Our ref: CBO-0049-007

22nd February 2012

A556 KNUTSFORD TO BOWDEN ENVIRONMENTAL IMPROVEMENT

Cuttings and embankments

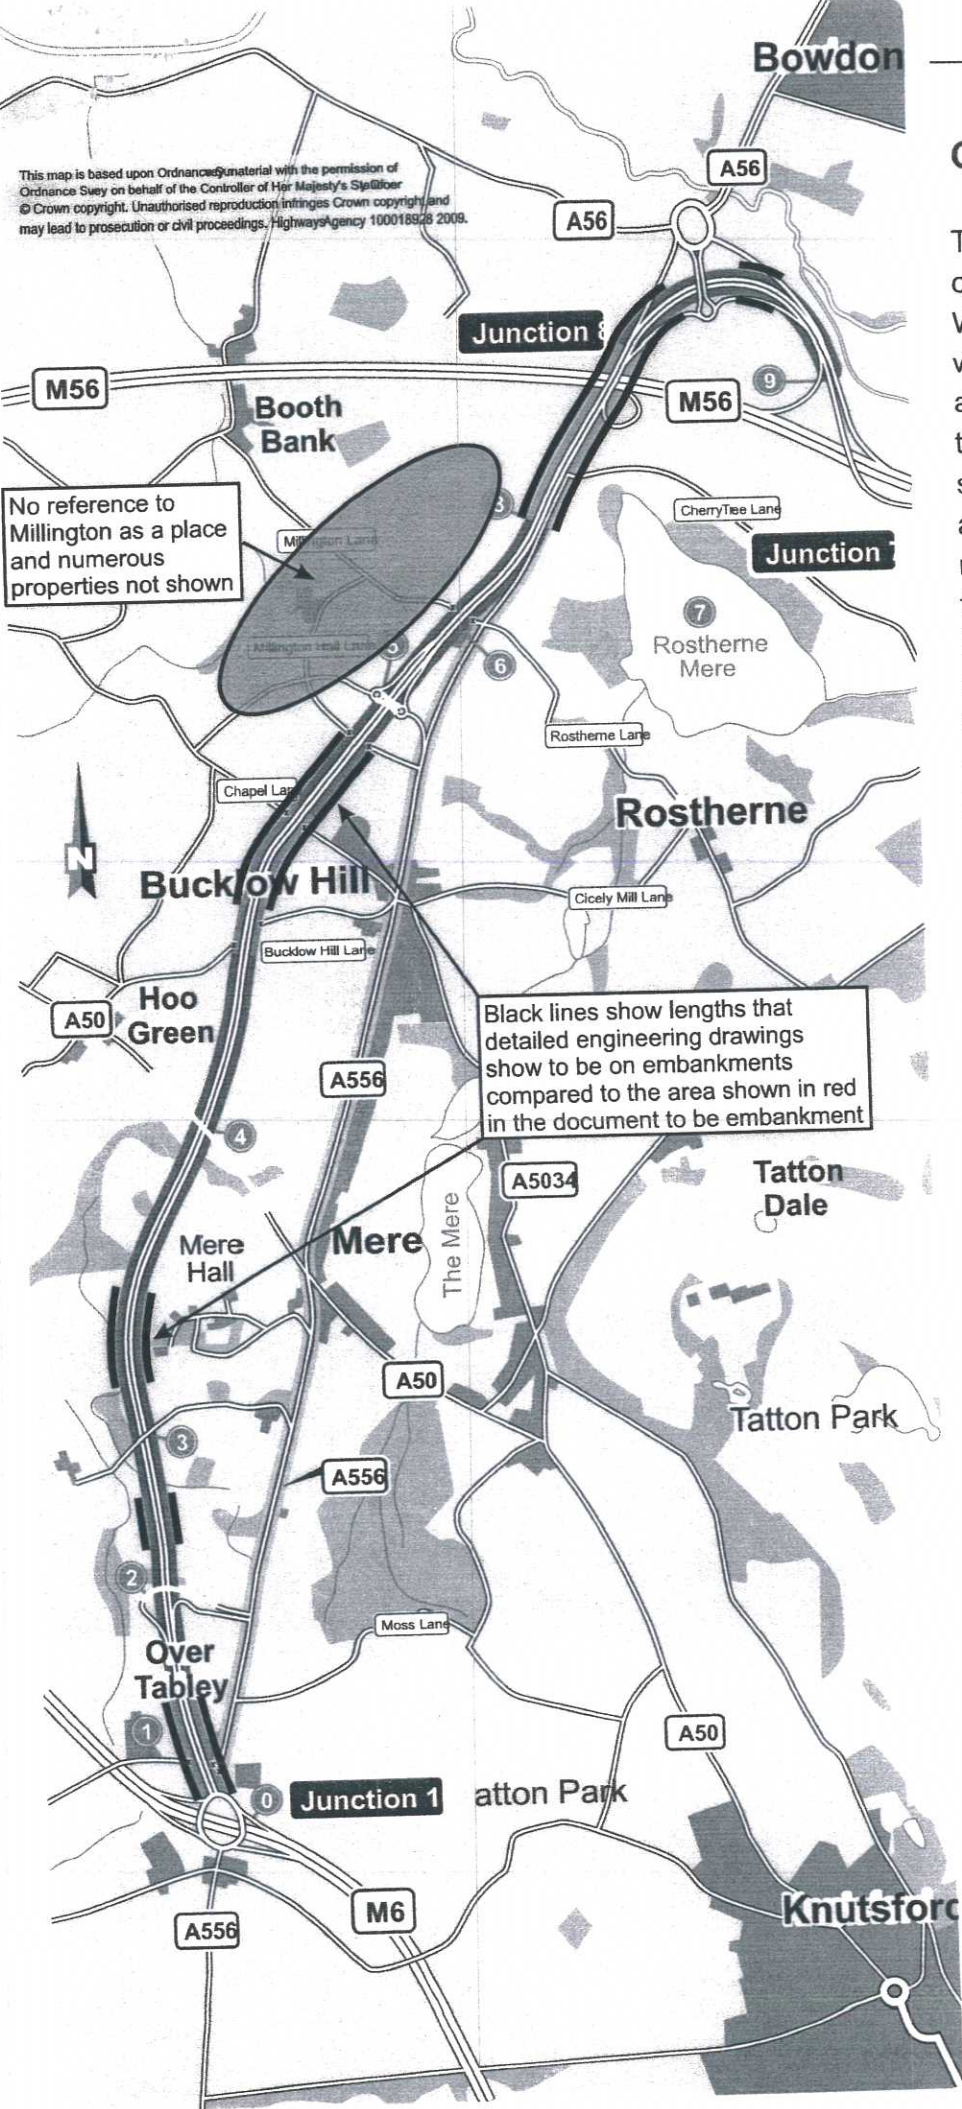
Millington however is not shown on the diagrams and there is no indication that there is any property in the vicinity of the scheme in this location. This is very misleading to anyone unfamiliar with the area and would obviously lead someone towards the conclusion that Millington was a good place to locate the road and a junction.

There are also inconsistencies between the engineering drawings and these schematic consultation plans in terms of the location of cuttings and embankments. On the south side of Millington the road is shown to be in cutting in the schematic consultation plans when in fact it is on embankment. For the audience these schematic plans are intended for, whether the road is in cutting or embankment is an absolutely key consideration. We have therefore enclosed a plan showing these discrepancies.
